**SSD-45024776 – Narwee Parklands Seniors Housing at 59-67 Karne Street North, Narwee**  
**Submission to the State Significant Development Application – Canterbury Bankstown City Council**

**Attachment A**  
**State Significant Development Application SSD-45024776 – Canterbury Bankstown**  
**Council Submission**  
**59-67 Karne Street North, Narwee**

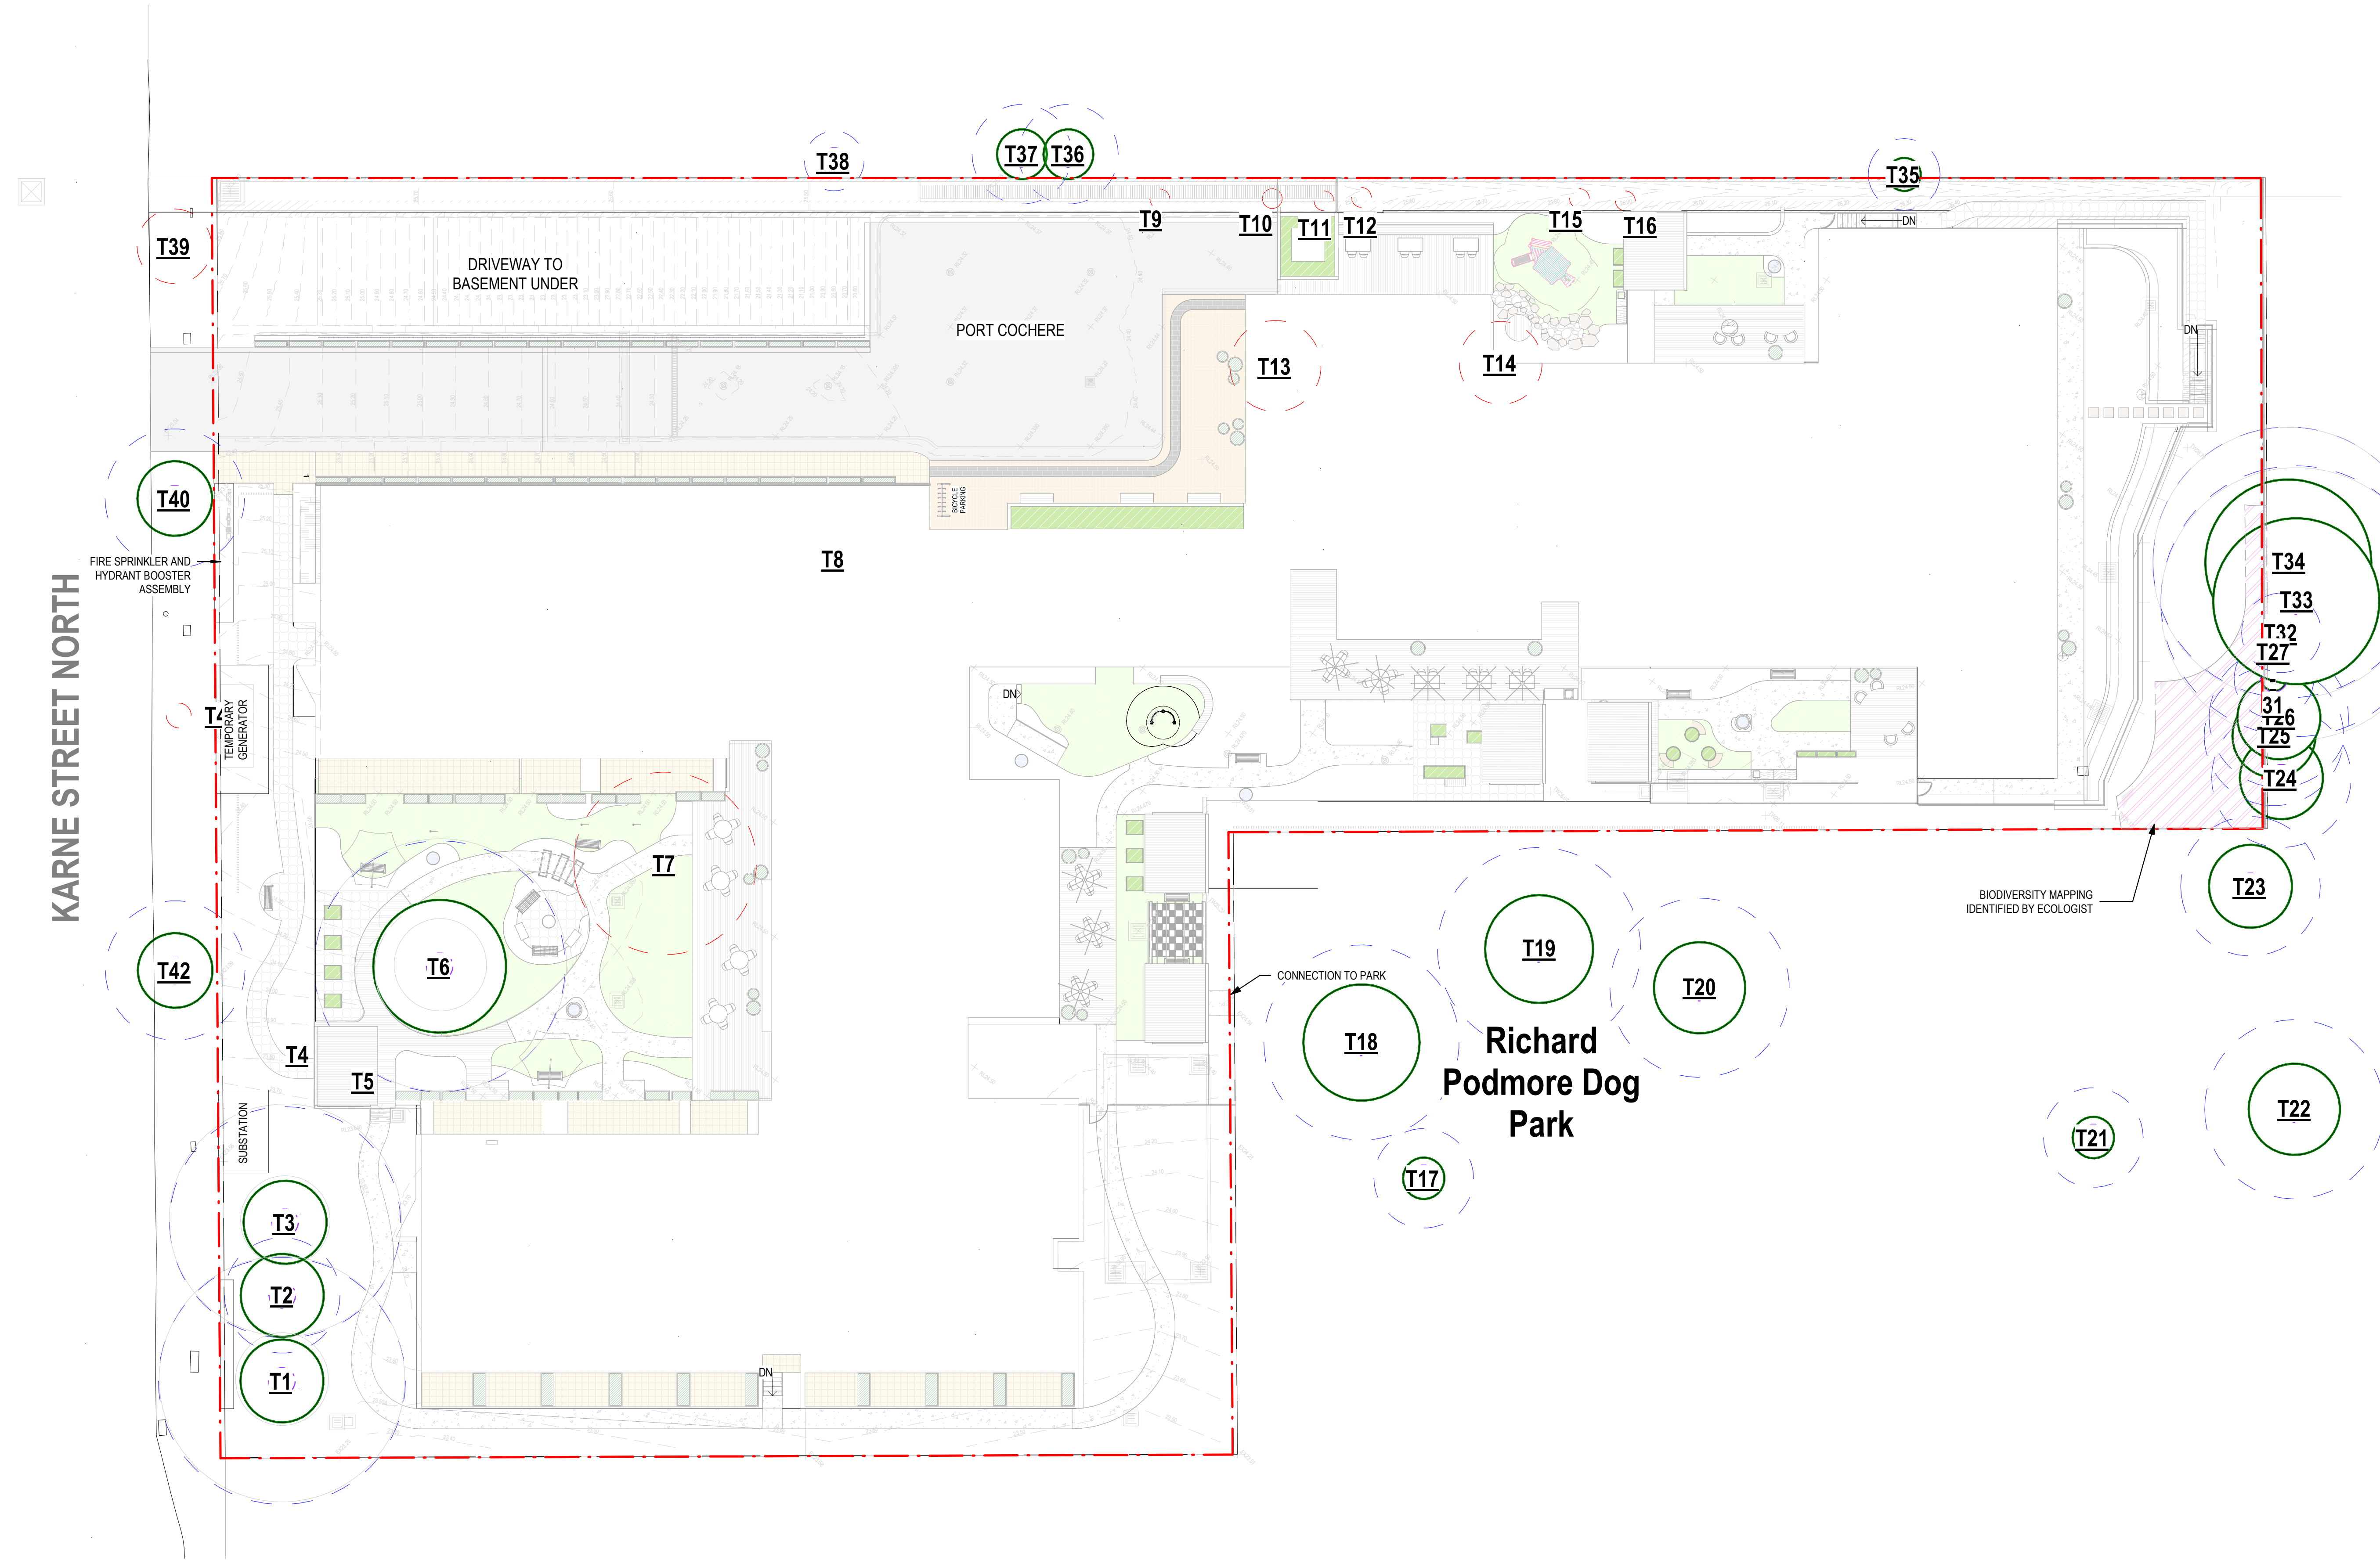
- Additional information requested
  - 1) Update landscape plans to include height of trees at maturity, amend species along the southern and eastern boundaries, and to address inconsistencies in the SSD Application documents in relation to tree removal and retention

| Item        | Council Feedback                                                                                                                                                                                                                                                                                                                                                                                                                                                                                                                                                                                                                                                                                                                                                                                                  |
|-------------|-------------------------------------------------------------------------------------------------------------------------------------------------------------------------------------------------------------------------------------------------------------------------------------------------------------------------------------------------------------------------------------------------------------------------------------------------------------------------------------------------------------------------------------------------------------------------------------------------------------------------------------------------------------------------------------------------------------------------------------------------------------------------------------------------------------------|
| Landscaping | <p>The landscape plans/documentation should be updated to include the following information:</p> <ul style="list-style-type: none"> <li>• Heights of all trees at maturity in accordance with the Secretary's Environmental Assessment Requirements (SEARs)</li> <li>• Further detail in relation to the proposal's contribution to increased urban tree canopy cover or mitigation of urban heat island effect in accordance with the SEARs</li> <li>• The landscaping along the southern and eastern boundaries should utilise species consistent with the Plant Community Type (PCT) classification 3448 (Castlereagh Ironbark Forest). The landscaping in this area should also be managed under a Vegetation Management Plan prepared by a suitably qualified person (please see Figure 1 below).</li> </ul> |

- Tree 39 is identified on the architectural plans to be located on the street verge to the side of the adjoining property at 84 Grove Avenue, yet the Landscape Plans note it will be in front of the proposed development and removed. The plans should be amended for consistency. Based on a site visit, this tree is located as per the Architectural plans.
- Tree 40 located on Council land is identified in the Arboricultural report and Landscape plans for retention, yet the Architectural plans note it will be

| Item       | Council Feedback                                                                                                                                                                                                                                                                                                                                                                                                                                                                                                                                                                                                                                                                                                                                                                                                                                                                                                                                                                                                                                                                                                                                                                            |
|------------|---------------------------------------------------------------------------------------------------------------------------------------------------------------------------------------------------------------------------------------------------------------------------------------------------------------------------------------------------------------------------------------------------------------------------------------------------------------------------------------------------------------------------------------------------------------------------------------------------------------------------------------------------------------------------------------------------------------------------------------------------------------------------------------------------------------------------------------------------------------------------------------------------------------------------------------------------------------------------------------------------------------------------------------------------------------------------------------------------------------------------------------------------------------------------------------------|
|            | <p>removed. This tree should be retained as it provides a positive contribution to the Karne Street North streetscape. Council does not support its removal. As per the provided Arboricultural report (page 2), no excavation should occur within 1m of the tree. The Architectural plans conflict this advice as the tree is within 1m of the proposed driveway. Further clarification is requested to ensure this tree is retained.</p> <ul style="list-style-type: none"> <li>• Tree 41 located on Council land is noted as removed as it had died. This tree must be replaced with a new street tree which needs to be included on the plans.</li> <li>• There is ample opportunity for additional street trees along the site frontage to be planted. Council requests that the revised Landscape plan is submitted showing additional street trees to enhance the streetscape and contribute to increased tree canopy.</li> <li>• It is not clear on the plans if the protection measures recommended under the Arboricultural report can be implemented with the amount of excavation proposed. Please refer to the Excavation issue in this table for more information.</li> </ul> |
